Department of Planning and Environment

Our ref: DOC22/853428
Your ref: SSD-10272349

Subject: Response to Submissions - Yiribana Logistics Estate (SSD-10272349)

Attachment 1: Environment and Heritage Group comments in relation to proposed stormwater management strategy for Yiribana Logistics Estate (SSD-10272349)

STORMWATER DRAINAGE MASTER PLAN
SCALE 1:1000

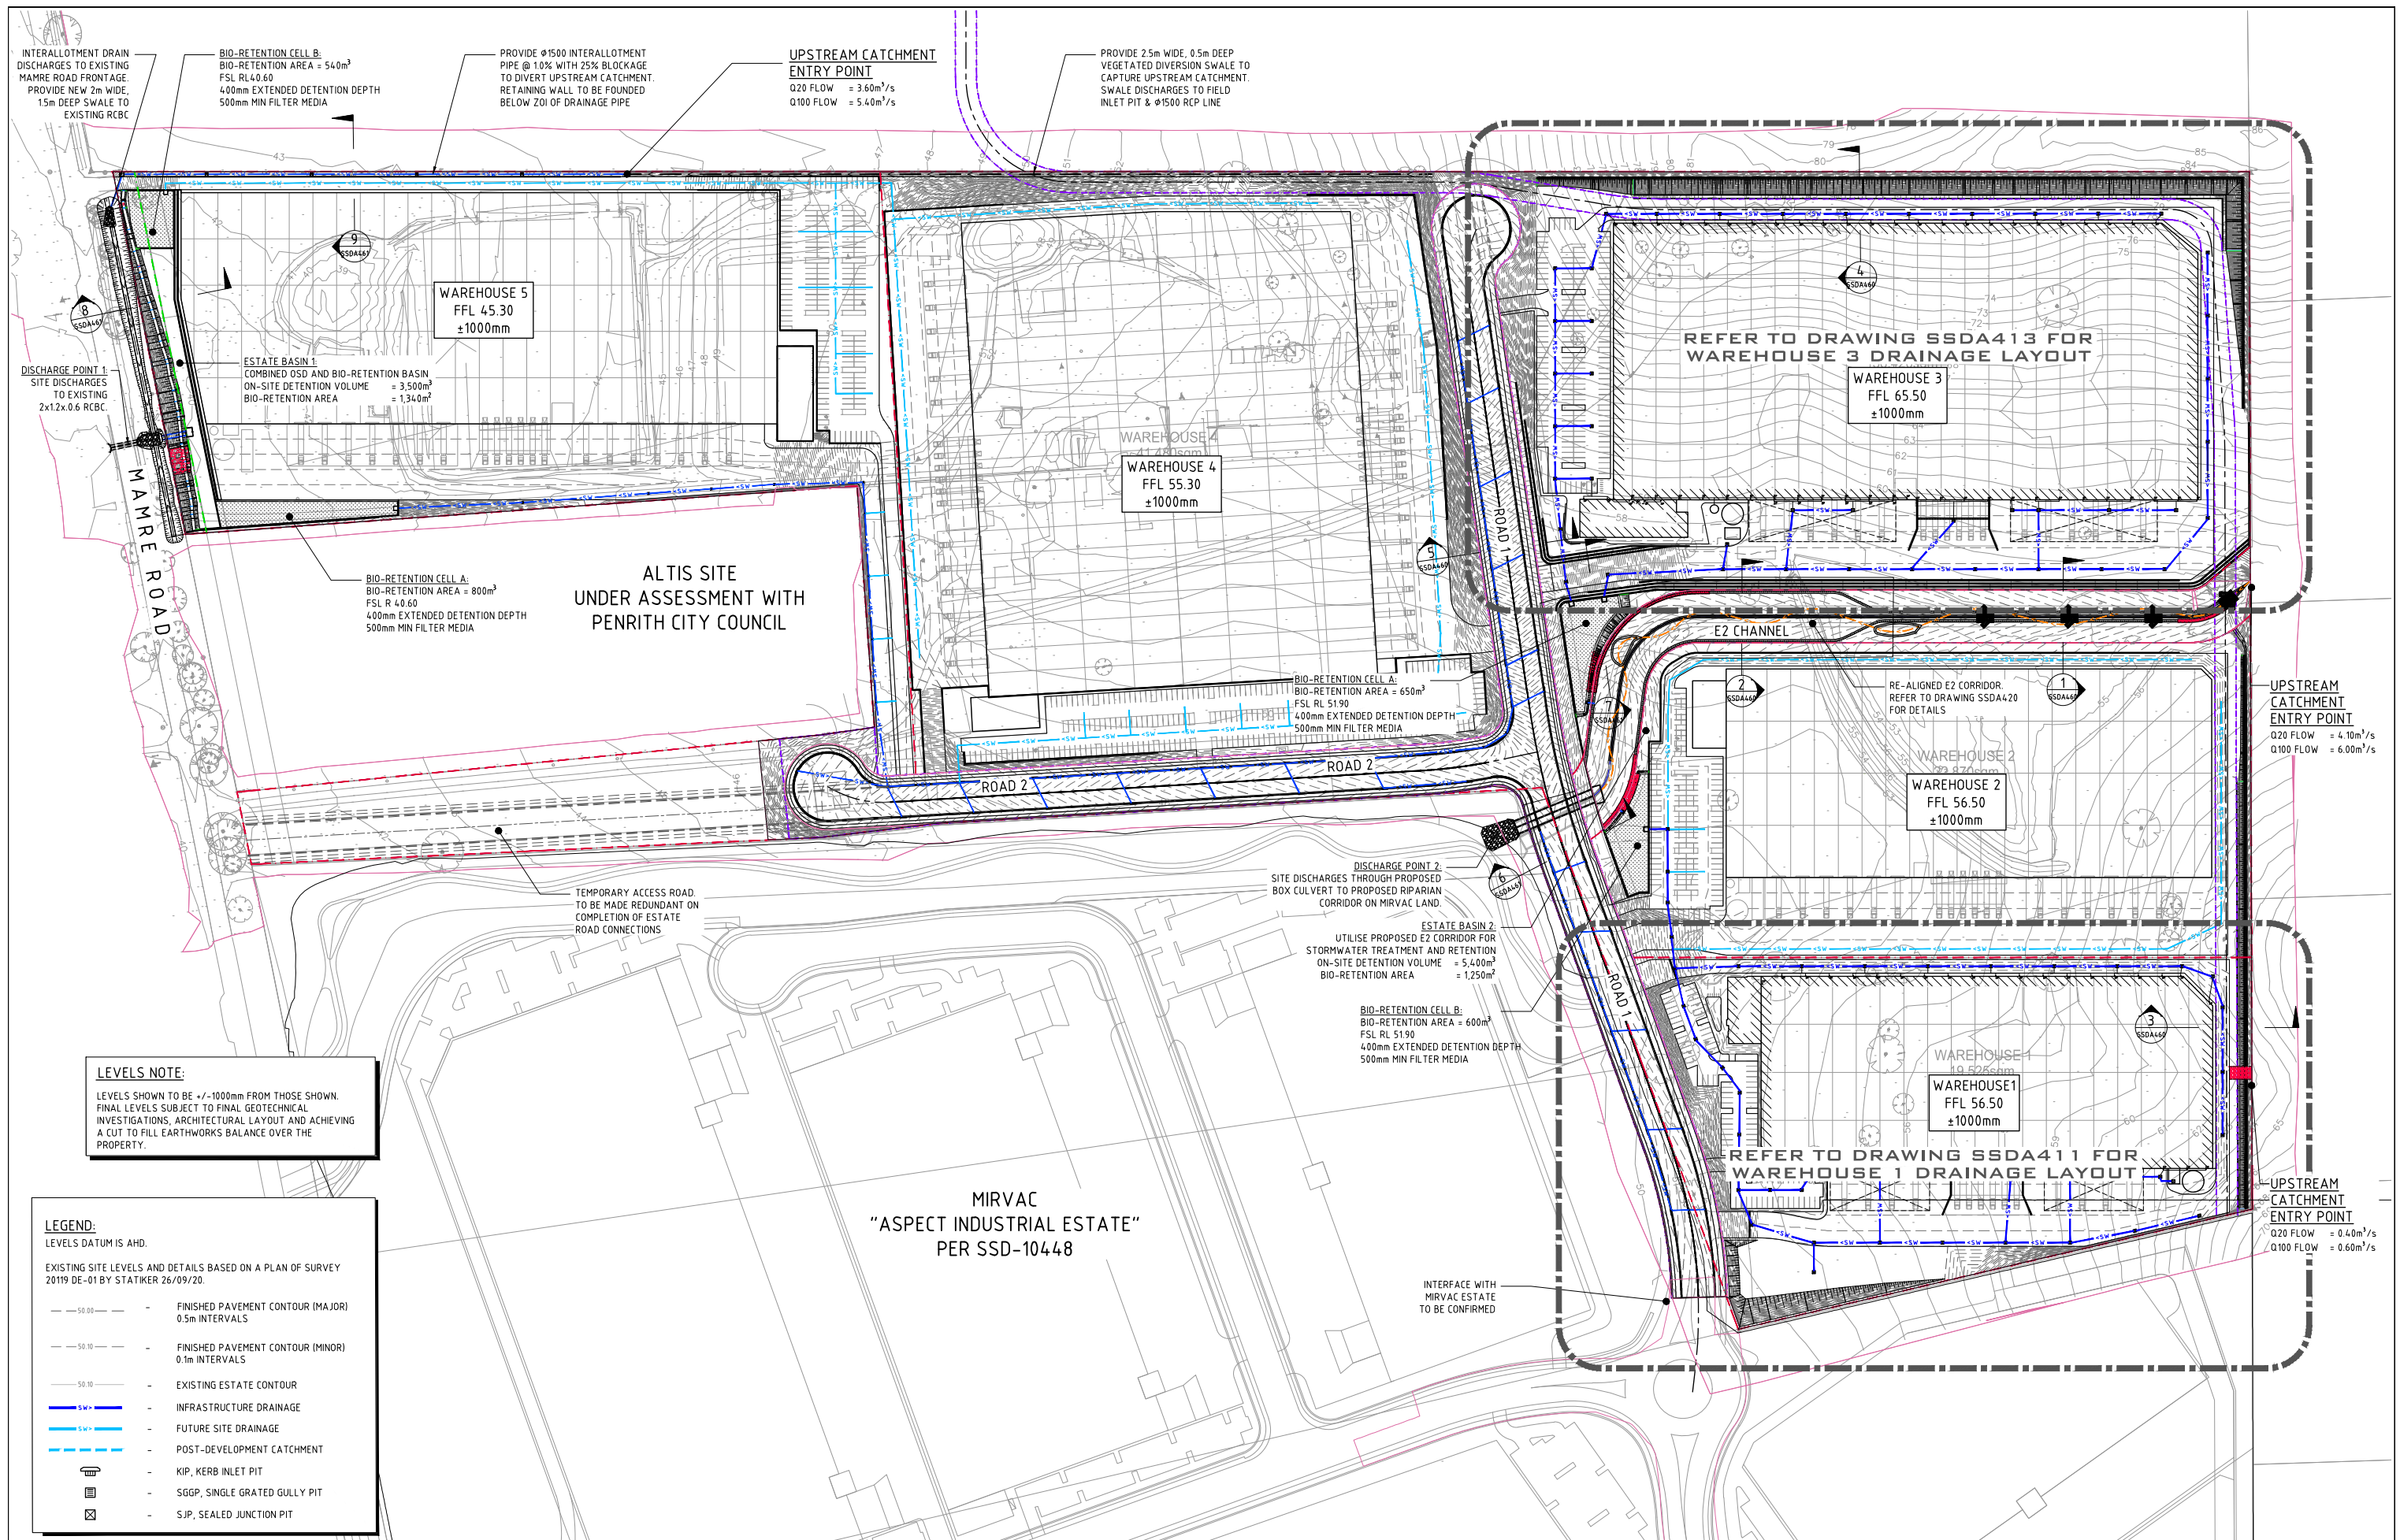
- The western 22.26ha external catchment enters the site into the proposed swale / waterway corridor and the online harvesting pond. Given the swale and pond are online to the external catchment, then this catchment needs to be included in the modelling. Currently the site is undeveloped but will ultimately be developed with WSUD. Both scenarios need be included in the strategy and modelling.

- The swale has been included in the MUSIC modelling to treat the development flows. However, development flows do not engage with the swale as they pass through the proposed bioretention systems and discharge to the proposed harvesting pond. The swale should be removed from the MUSIC model.

- To simplify the strategy and modelling, it is recommended that the harvesting pond is moved offline (refer potential alternative strategy at Attachment 2).

- It is unclear if the northern 20.42ha external catchment to the north has been modelled to confirm the diversion channel/pipe requirements.

**POST DEVELOPMENT
STORMWATER CATCHMENT PLAN**
SCALE 1:2000

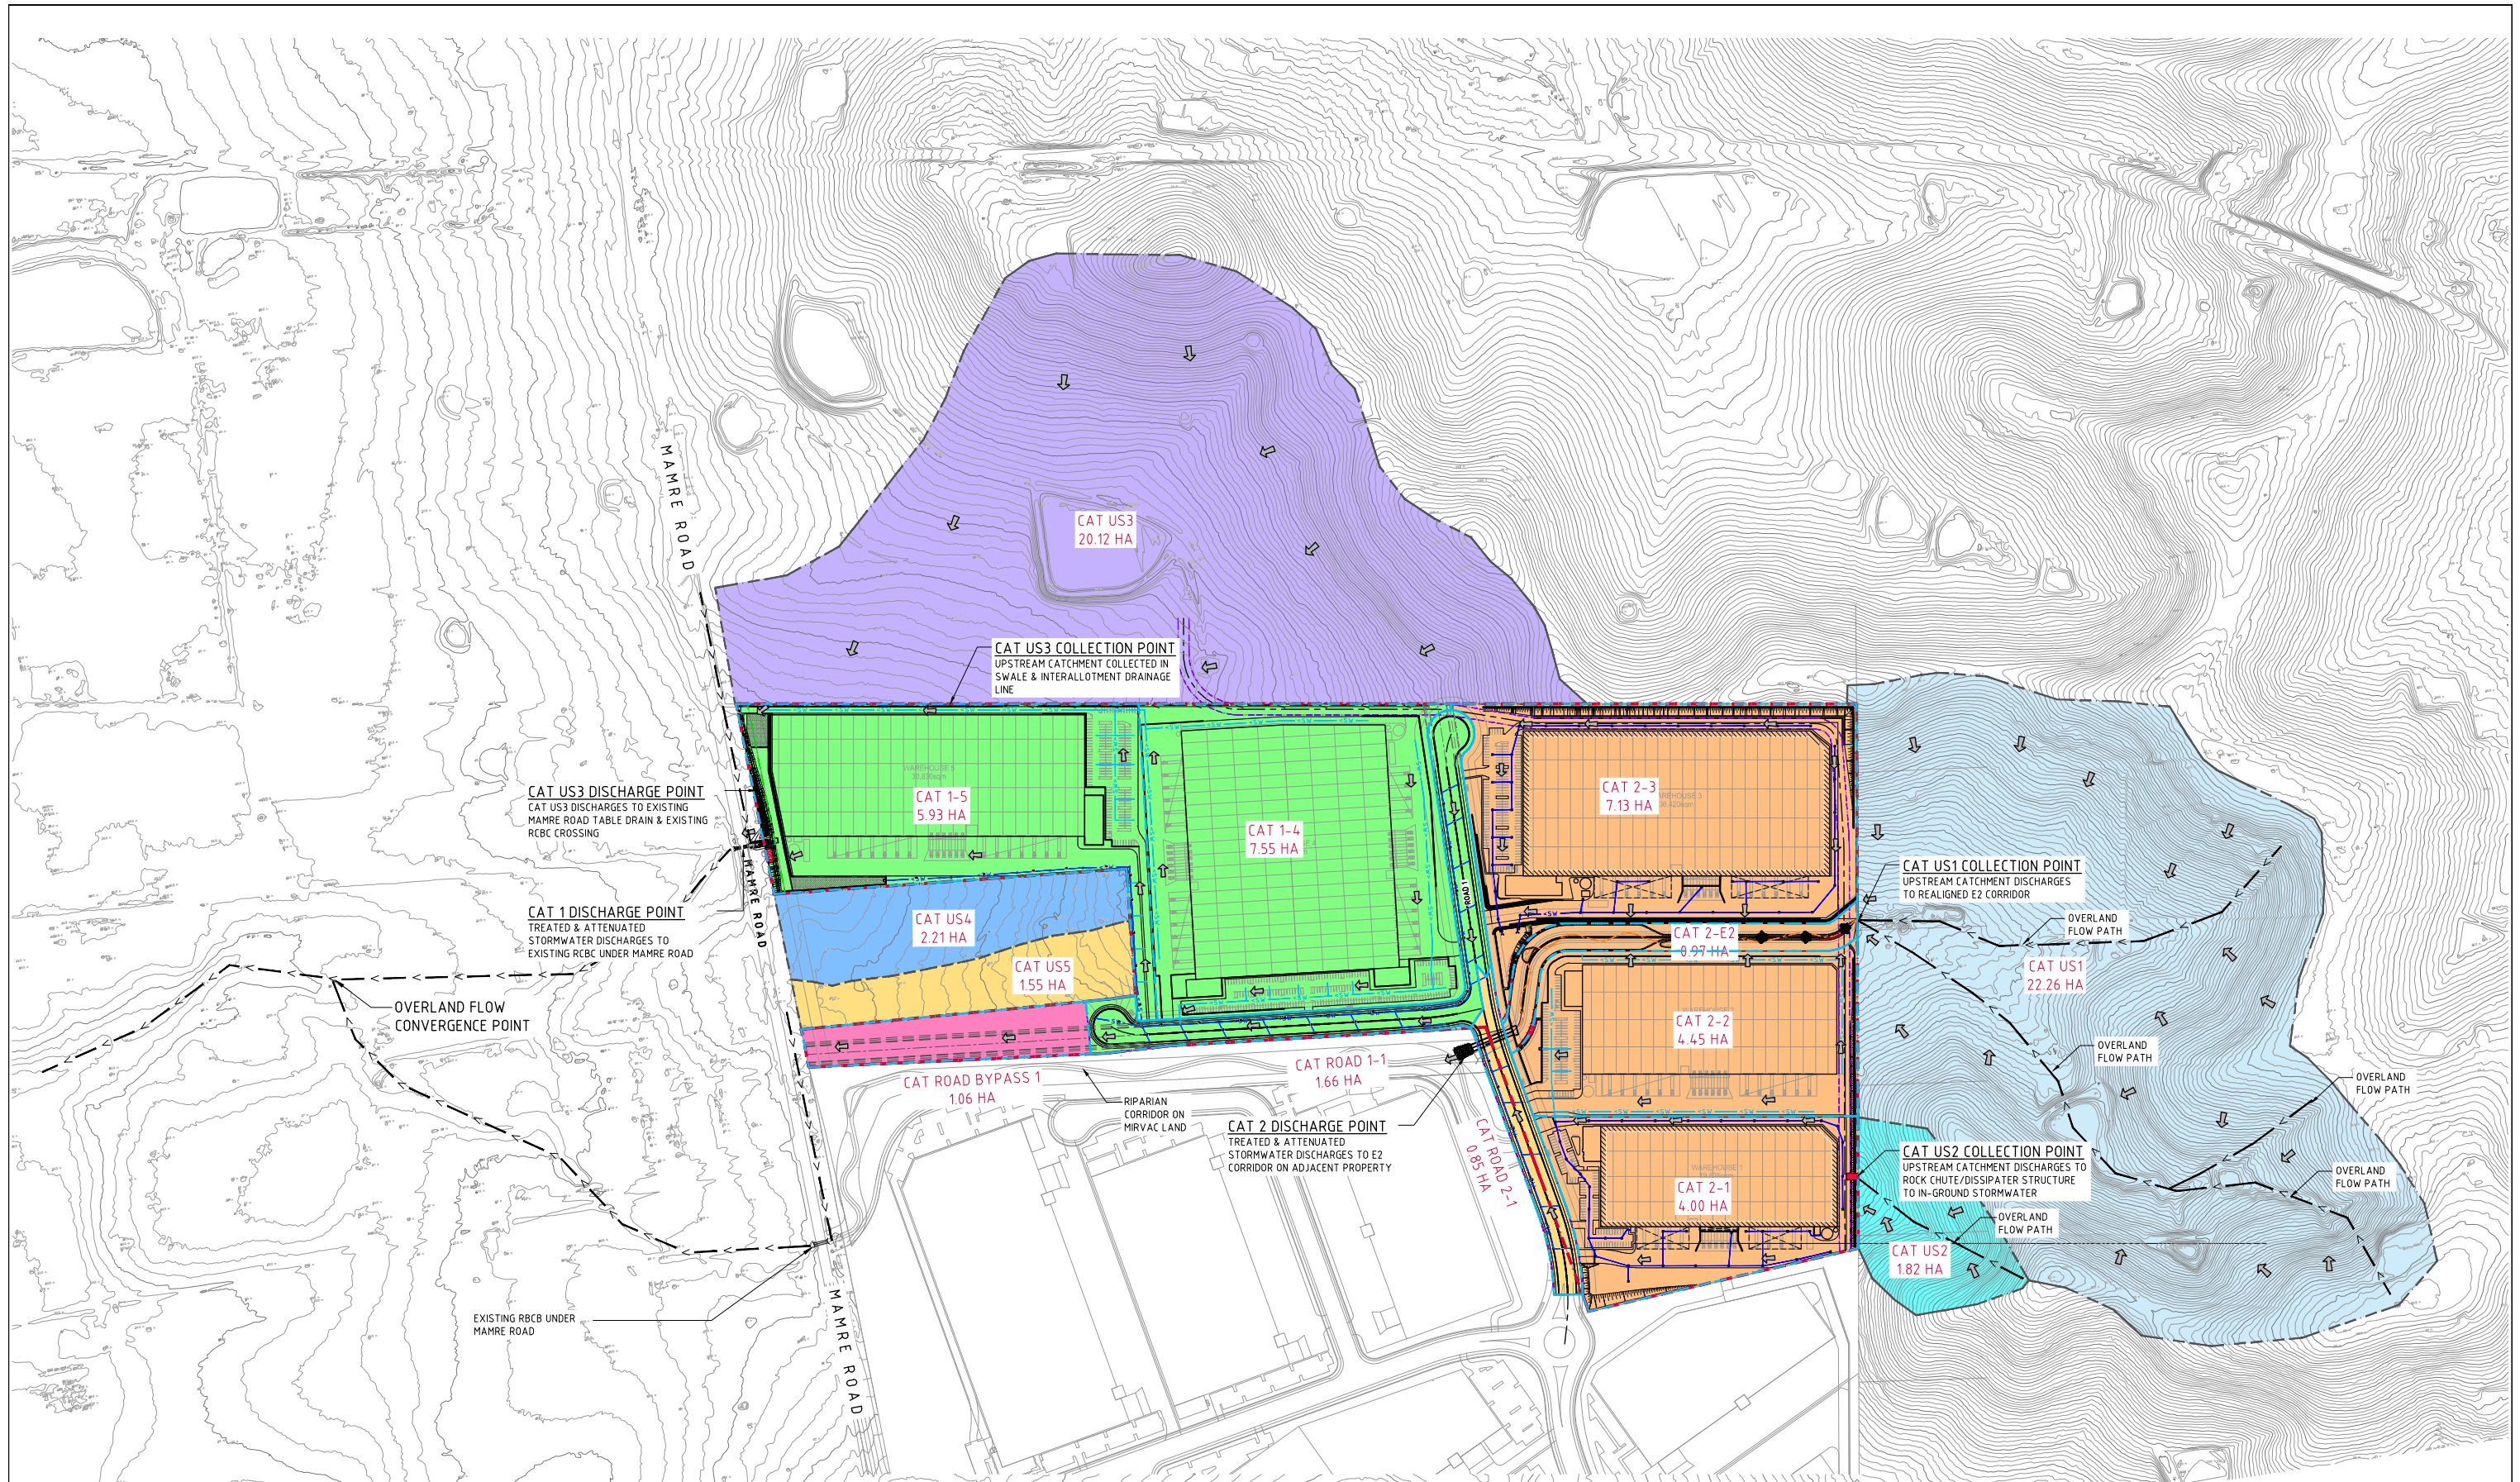
No catchment/WSUD plan or table has been included in the reporting. A plan and table must be provided showing:

- all catchments and land use splits (and areas/% impervious)
- drainage locations and any flow diversions/splits
- WSUD systems
- proposed irrigation areas for tanks and ponds.

- External Catchment - If the online swale and harvesting pond are to be retained in the strategy, then the external catchment existing and post development will need to be considered in the modelling.
